**KIRKLEES METROPOLITAN COUNCIL
INVESTMENT & REGENERATION SERVICE**

Reference No:	2024/62/92984/E
Site Address:	34, Rydal Grove, Roberttown, Liversedge, WF15 7DN
Description:	Erection of two storey rear extension and associated alterations
Recommending Officer:	Edward Cheseldine

HOUSEHOLDER DELEGATED REPORT

Proposed Block Plan

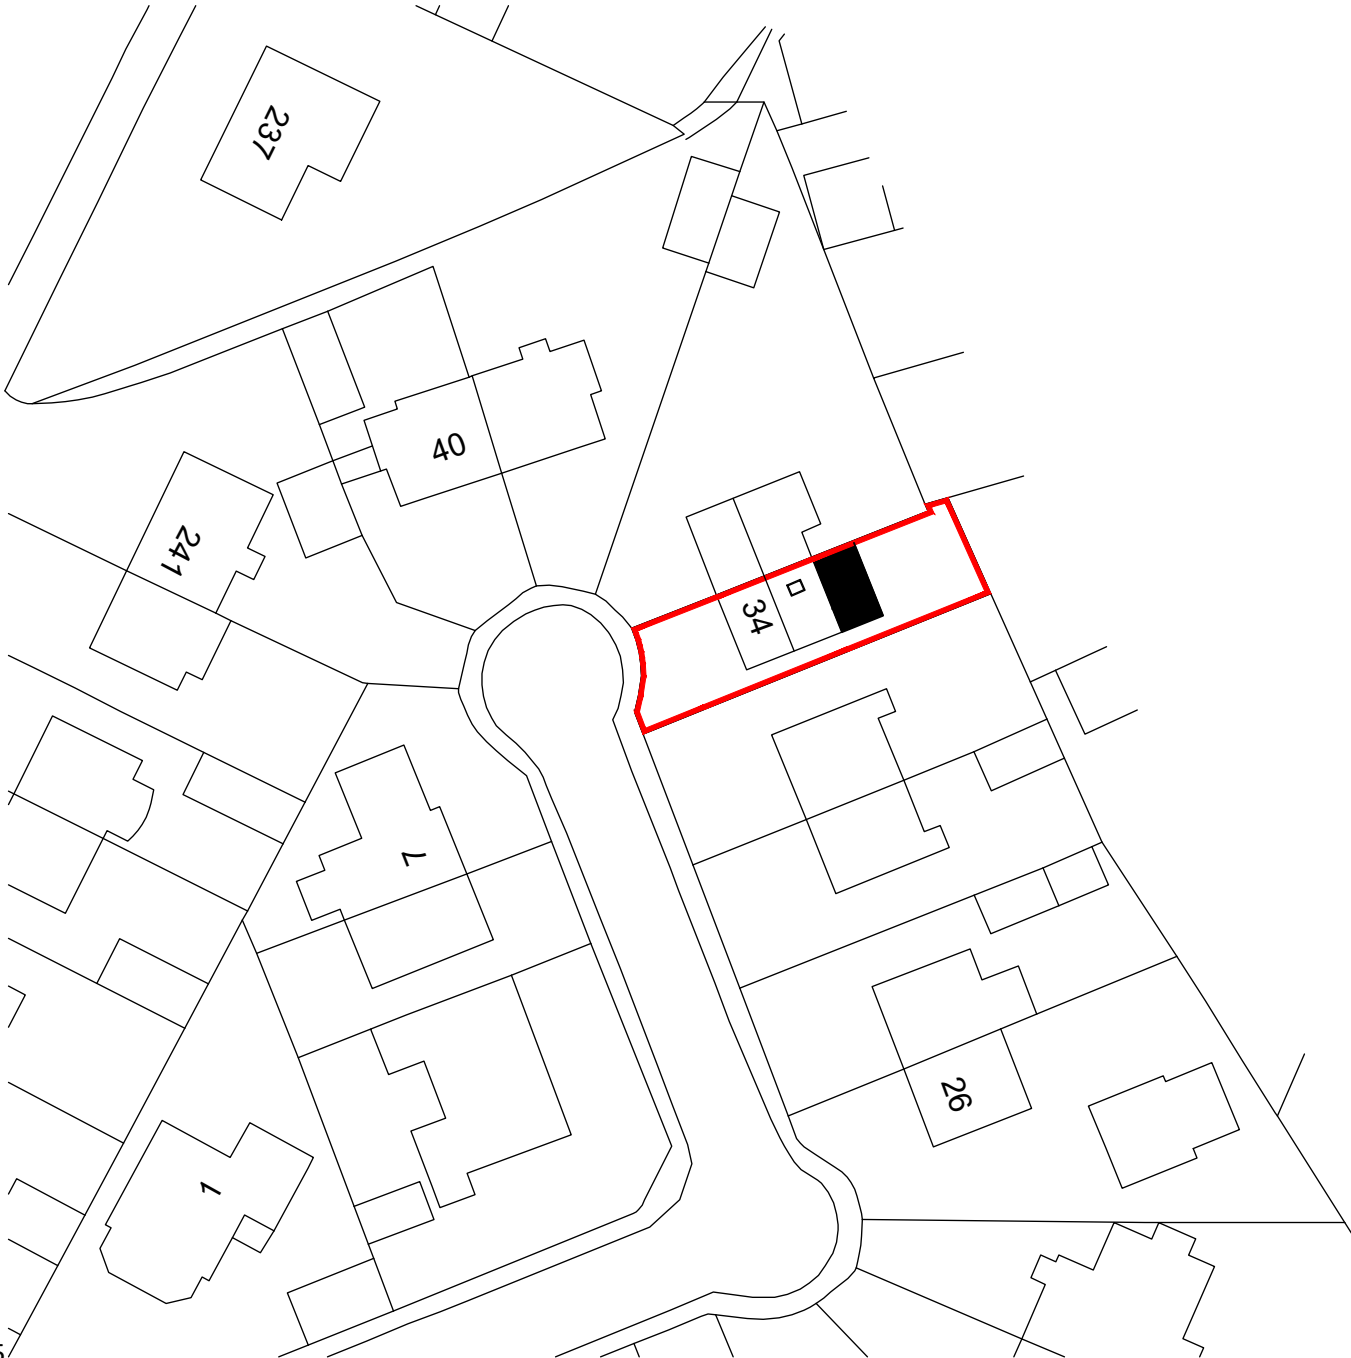
<u>Yes - COMPLY</u>	<u>No - JUSTIFY</u>
Be proportionate to the size of the original house and garden	Yes - Footprint calculations indicate there would be a less than 50% increase. The property has a modest residential curtilage, a significant proportion of which will be maintained.	
Not normally exceed 50% of the total area of land around the original house (including previous extensions and outbuildings)	Yes – Footprint calculation show there would be a less than 50% increase in terms of building. A significant proportion residential

General Arrangement as Proposed

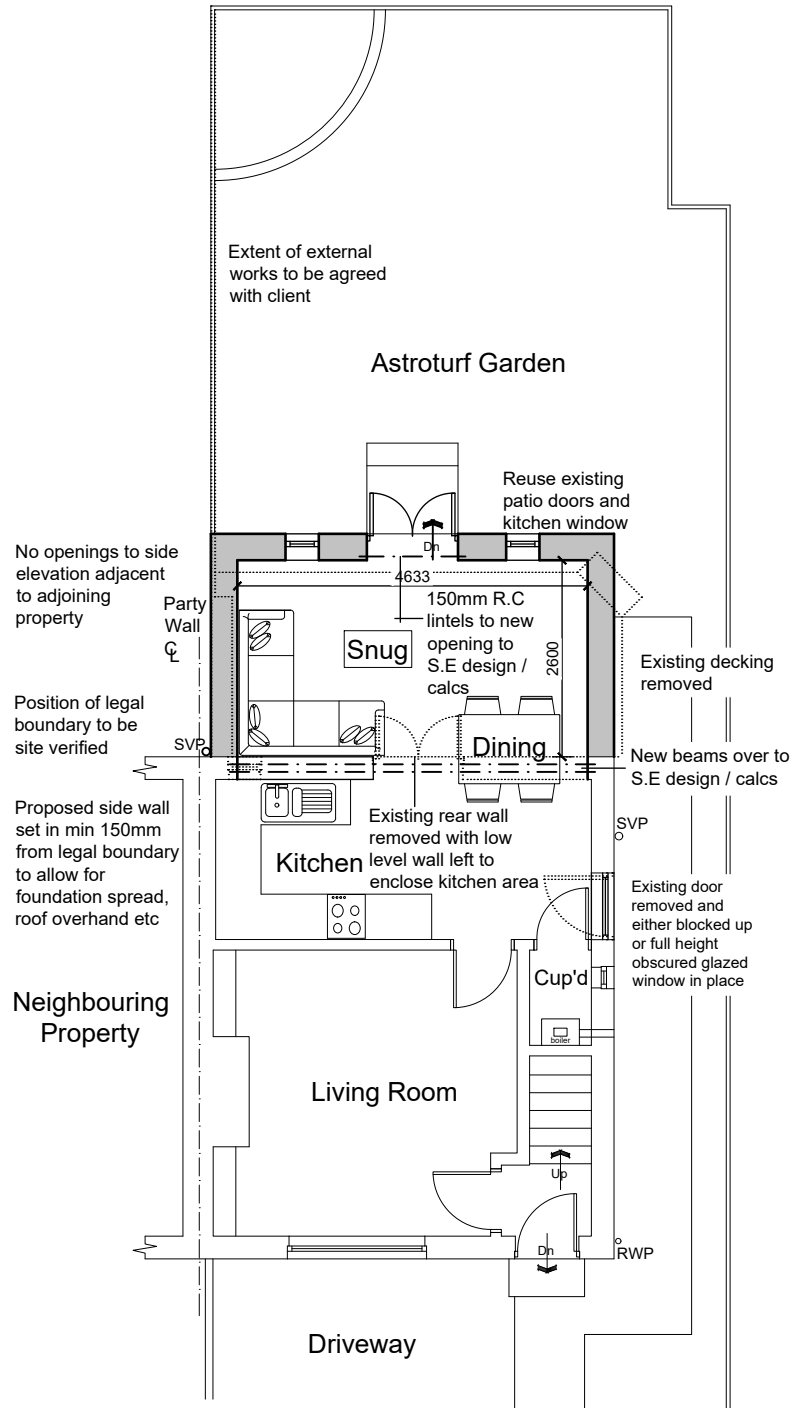
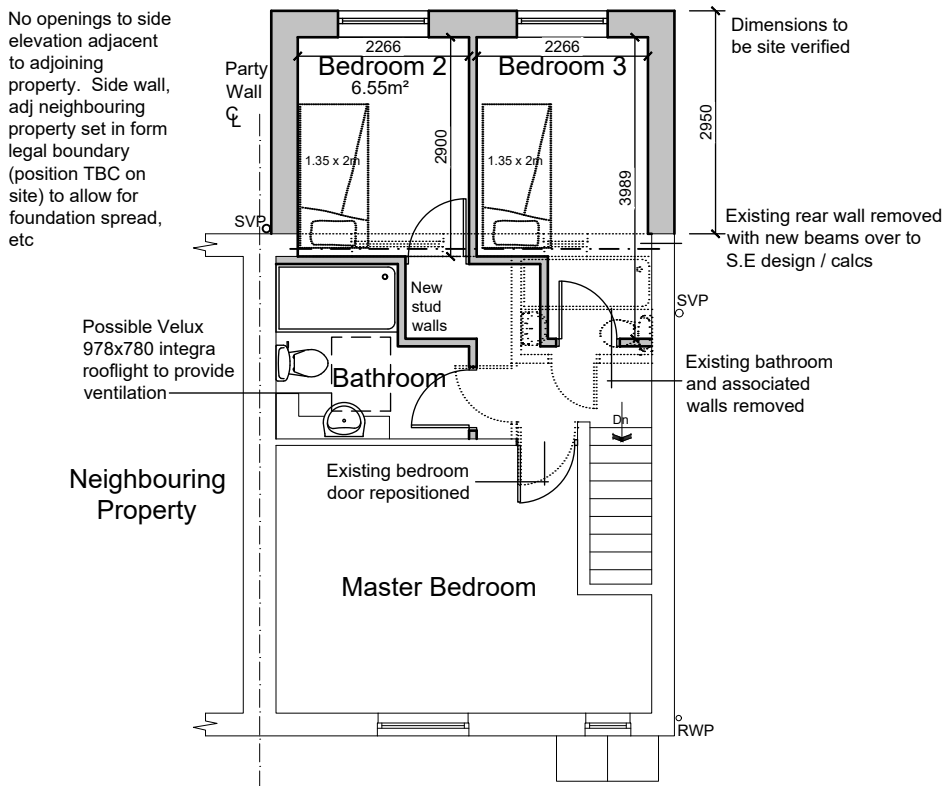
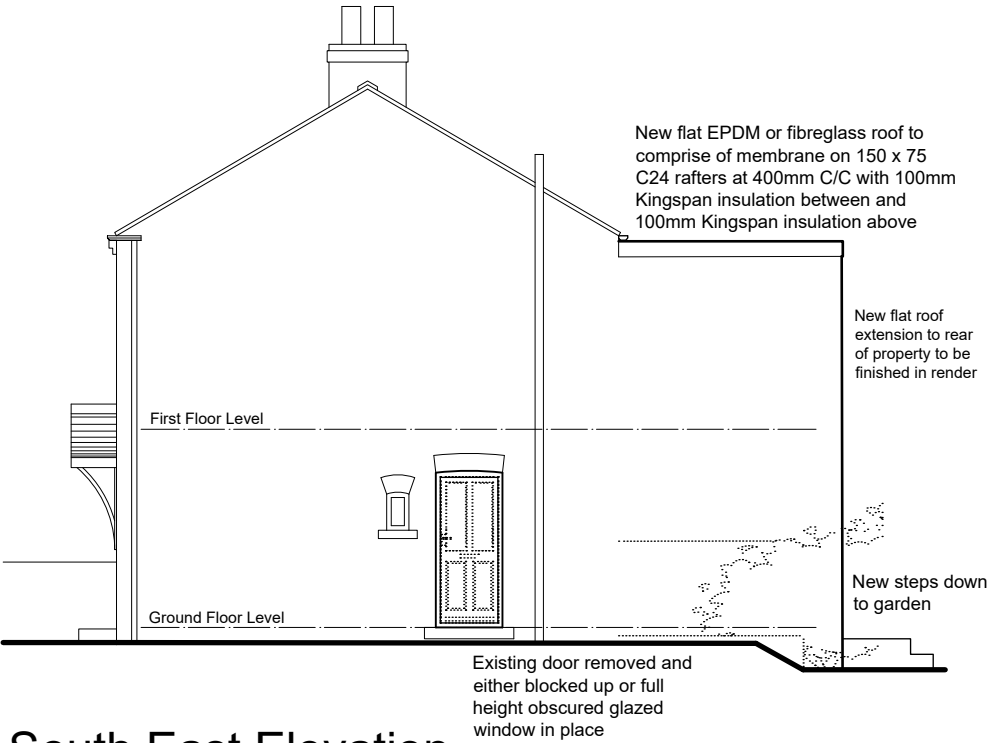
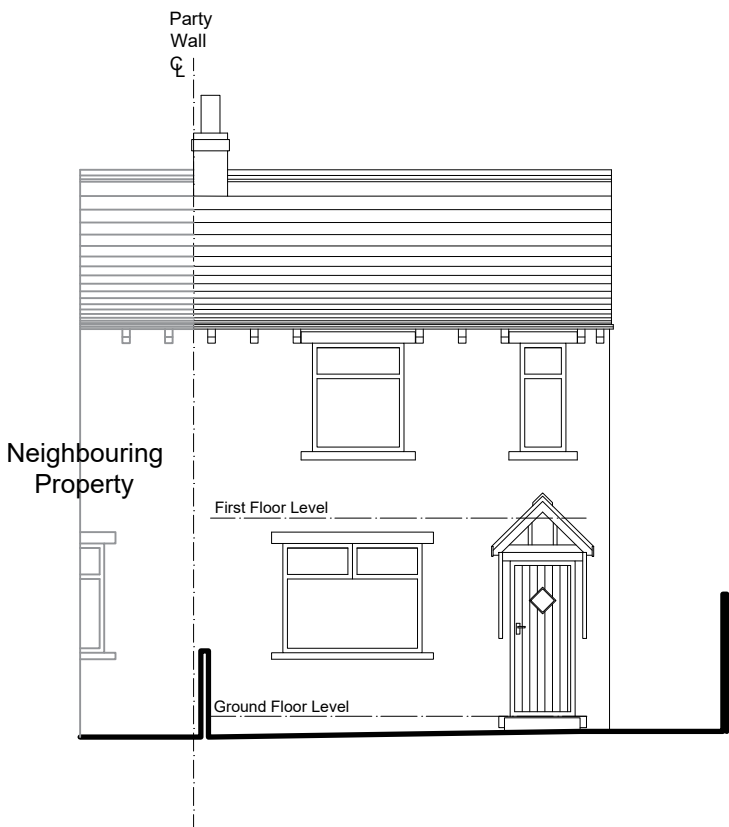
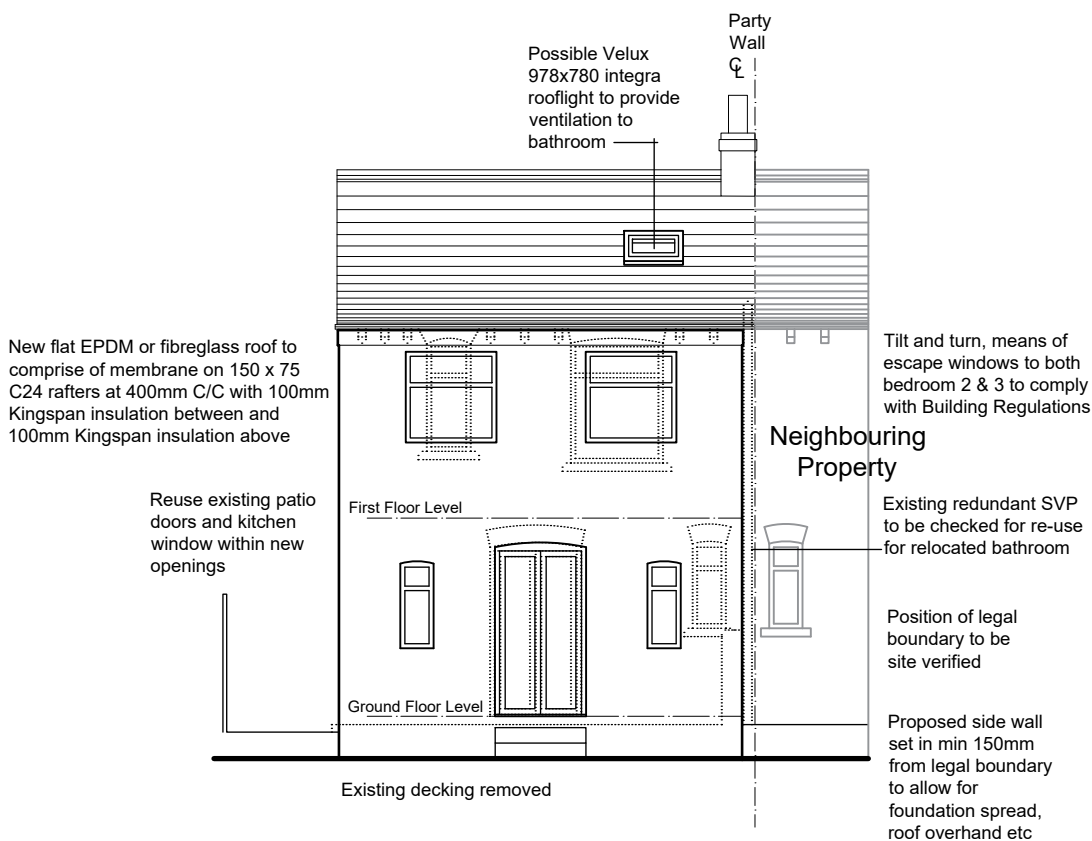
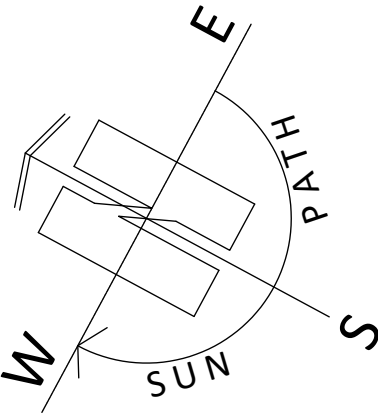
YES / NO	SUMMARY
Negotiations/Amendments during course of application	Yes	In order to satisfy a paragraph 1.11 of the House Extensions & Alterations Supplementary Planning Document, it was requested that a justification was submitted for the following:

• Justification for the height of the extension, potentially by, • Indicating a 45 degree angle of outlook is preserved from neighbouring rear windows. • Indicating what the ground-floor window of the adjacent property serves • Justification for the flat roof design A justification was received which is considered throughout the report.
Parish/Town Council comments sought	None	
Planning History	None relevant.	
Consultations required	None required.

In order to satisfy a paragraph 1.11 of the House Extensions & Alterations Supplementary Planning Document, it was requested that a justification was submitted for the following:

- Justification for the height of the extension, potentially by,
- Indicating a 45 degree angle of outlook is preserved from neighbouring rear windows.
- Indicating what the ground-floor window of the adjacent property serves
- Justification for the flat roof design

The supplied justification and accompanying site visit was sufficient in overcoming the design concerns.
